Large-scale Residential Development Appeal Observation

Online Reference
LRD-OBS-006512

Subject: Observation regarding Third Party appeal in respect of Dublin City Council
WEBLRD6093/26-S3B development proposal at Milltown Park, Ranelagh

Figure 3.8: Separation Distances Proposed with Large Setbacks from Block C and 2 No. Storey Courtyard Houses in Block E Highlighted

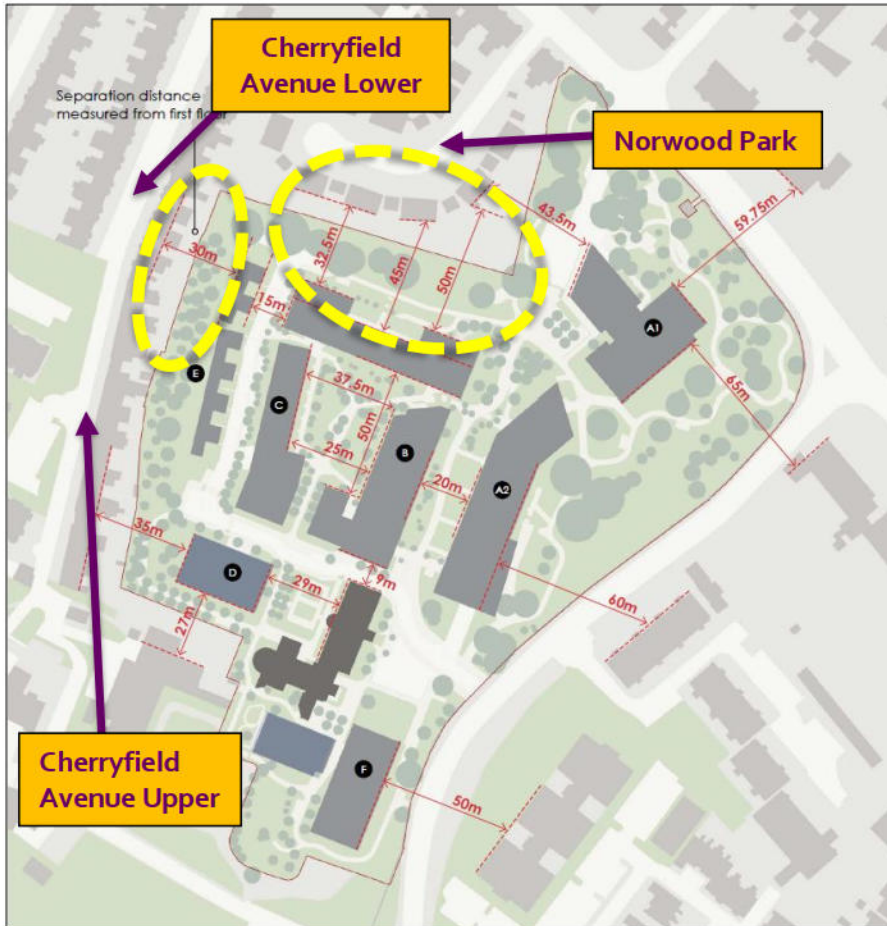
It is infuriating to note that the planning officer has stated in their report that Block E does not affect the residents of Upper Cherryfield Avenue, only Lower Cherryfield Avenue. Having lived in Upper Cherryfield Avenue for more than 40 years, I can very

much confirm that my home is definitely in Upper Cherryfield Avenue and is directly to the North of the proposed Block E. As a named third-party appellant of the most recent SHD application on this site which has been referred to the board, one would imagine that increased consideration would have been given to my home as part of any revised proposals for this site. In actuality, it appears that the Planning officer has chosen to do the exact opposite and just chosen to ignore my home.

Block E is, and always has been, a problematic proposal in the various revisions of this scheme. The current proposal is clearly a strained response by the architects to respond to pressure from the applicant to at least get some sort of development on this piece of land. The six proposed two-storey houses are equally problematic as the previous rendition. They are cheap looking, squat, stumpy and very poorly rendered from an architectural perspective. They are reminiscent of defensive bunkers as opposed to homes, and are no more in keeping with local character than a bunker would be, which is to say, not at all.

I would further note that the planning officer has stated that Block E is c. 30 meters away from the Cherryfield avenue houses. Again, this is wholly inaccurate as my rear bedroom window is well within this distance.

I ask that should An Comisiún decide to grant permission for this development, that Block E be conditioned out entirely, or at the very least 6 additional family apartments are provided within the main, larger block along Milltown road and the existing Block E lands remain as external space.
